# CITY OF ALBUQUERQUE

**RE:** The New Altos Pool  
Conceptual Grading and Drainage Plan  
Engineer's Stamp Date 2-21-2017 (File: K20D037)

Based upon the information provided in your submittal received 2-21-2017, the above referenced Grading and Drainage Plan cannot be approved for Site Plan for building permit until the following comment are addressed:

101.1

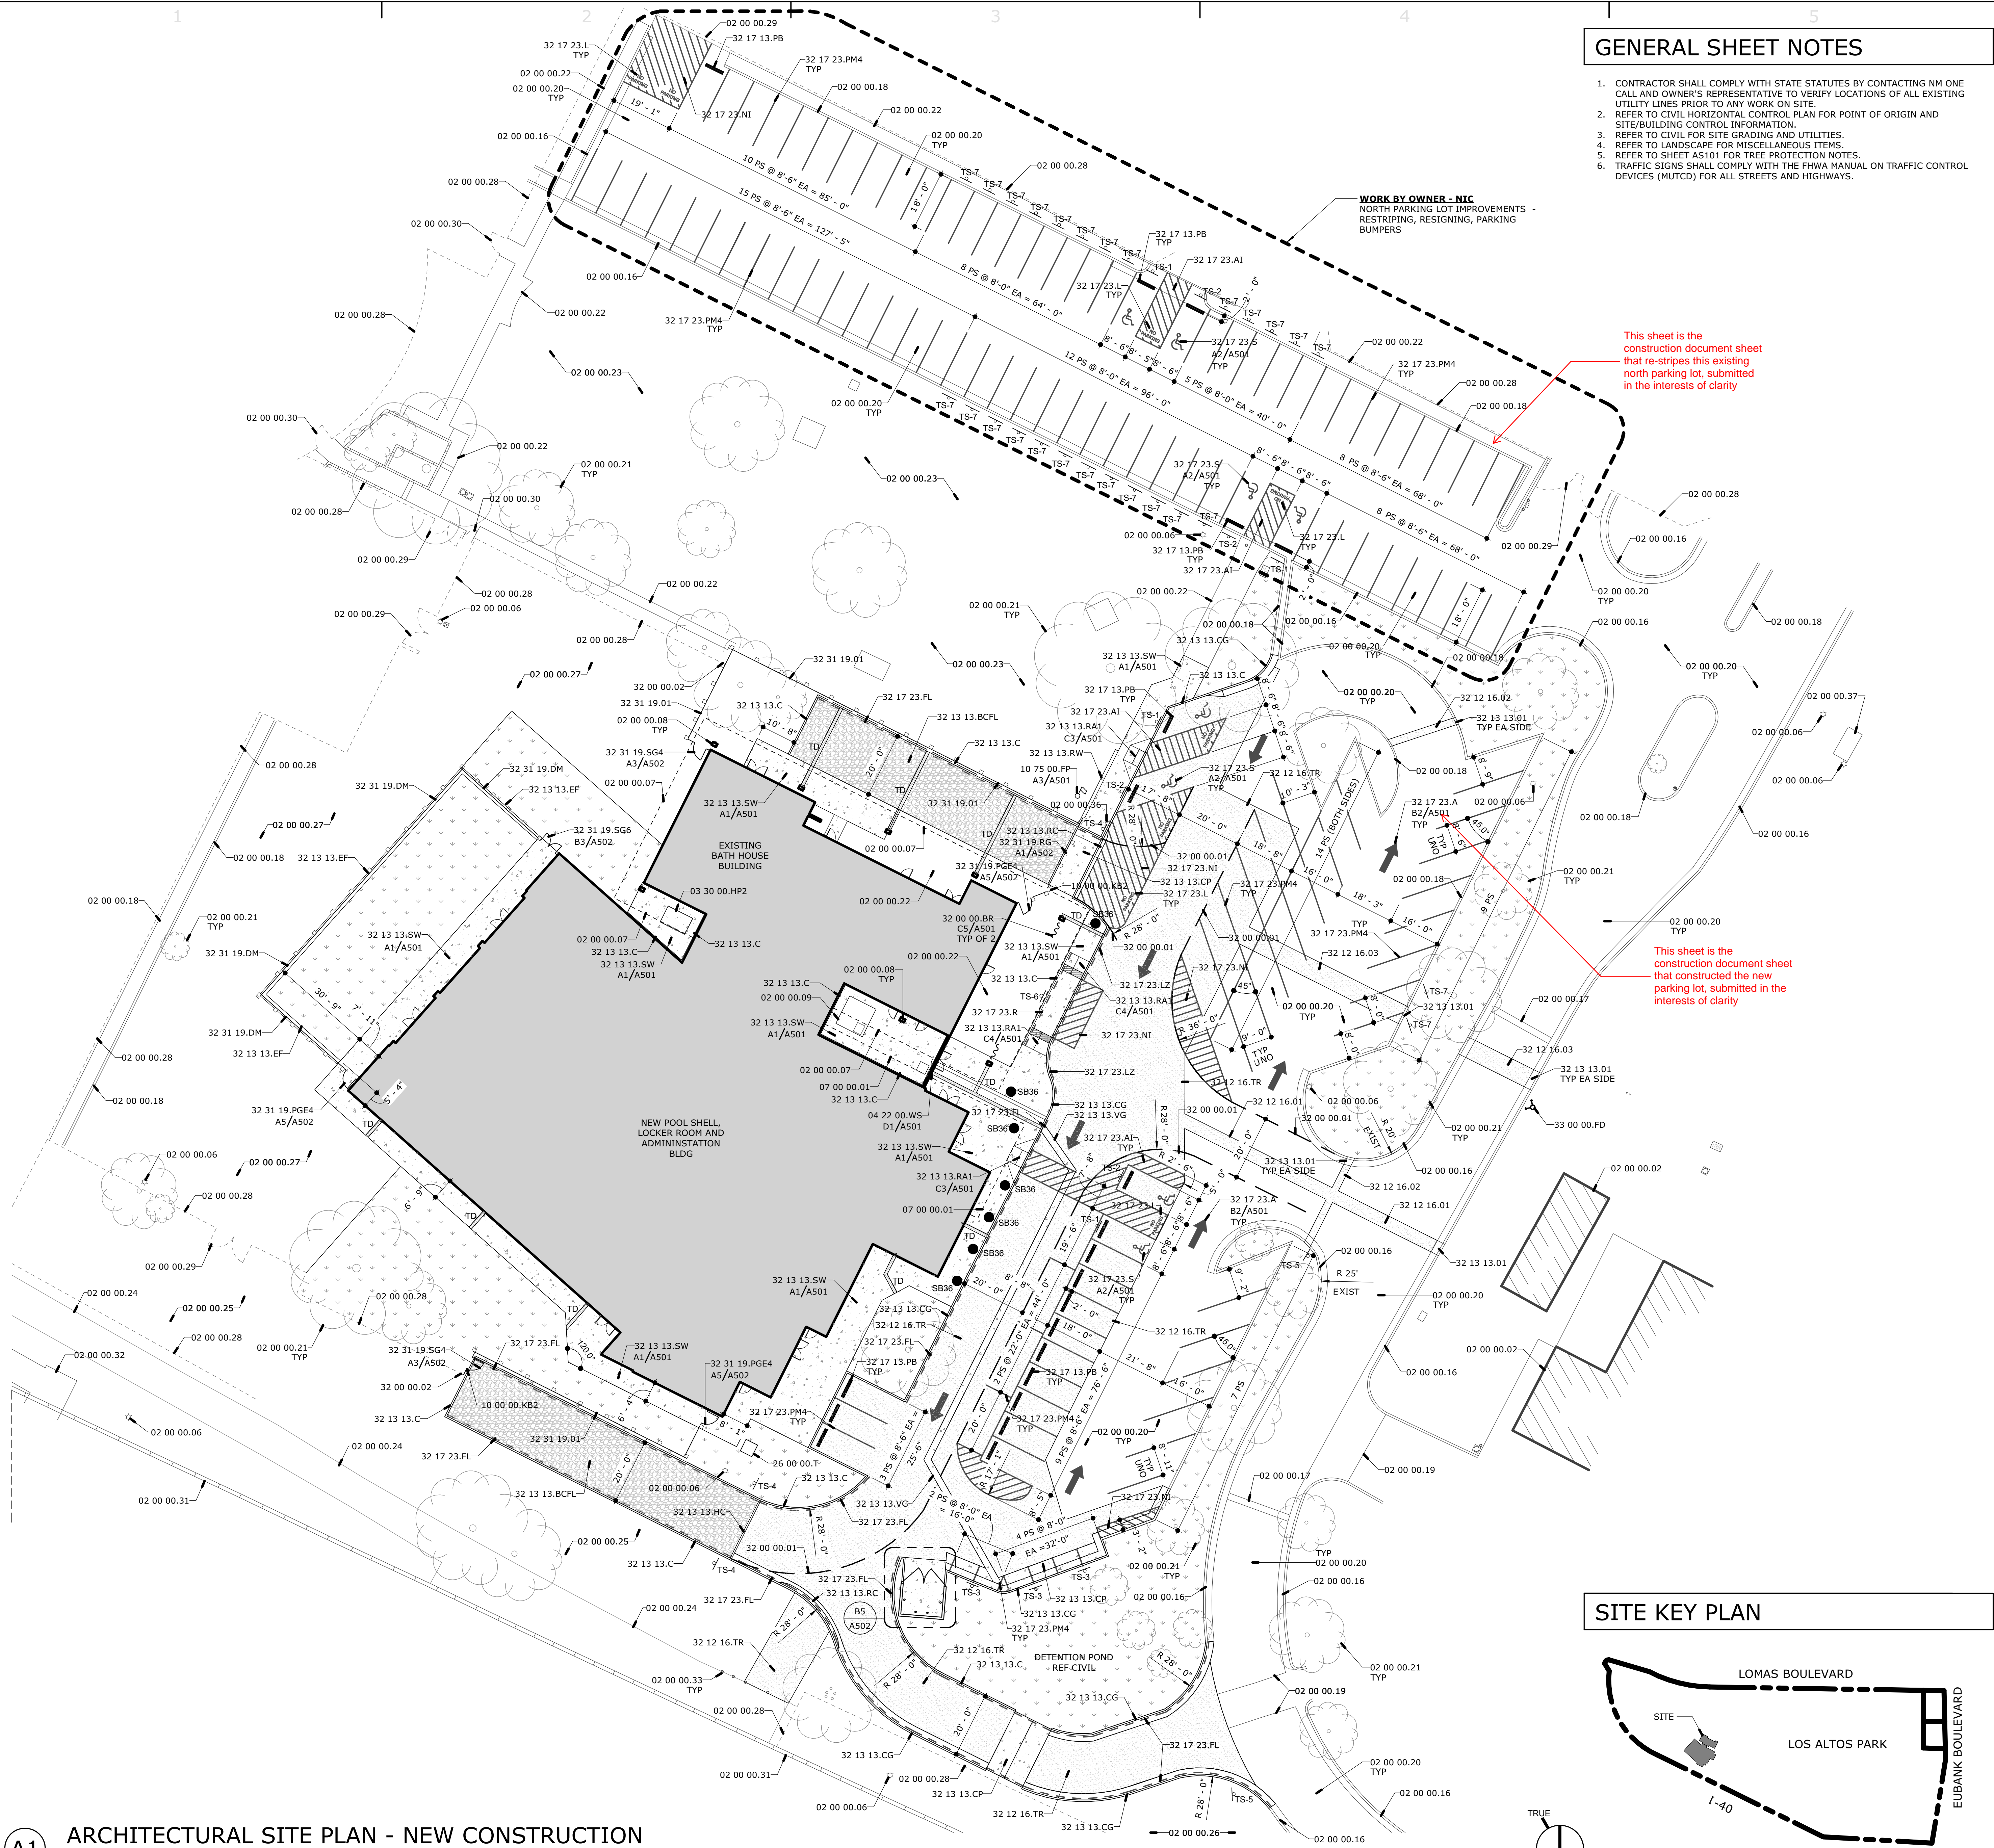
1. Curb opening details.
2. Build note for demolished curb and landscape area on the parking lot east side of the site.
3. Runoff entering the landscaping area appear to drain over the sidewalk. Provide sidewalk culvert at this location.
4. It appears another sidewalk culvert is being proposed east of the metal shed north of the building expansion. Please provide labels for this culvert.
5. Provide inverts for all culverts.
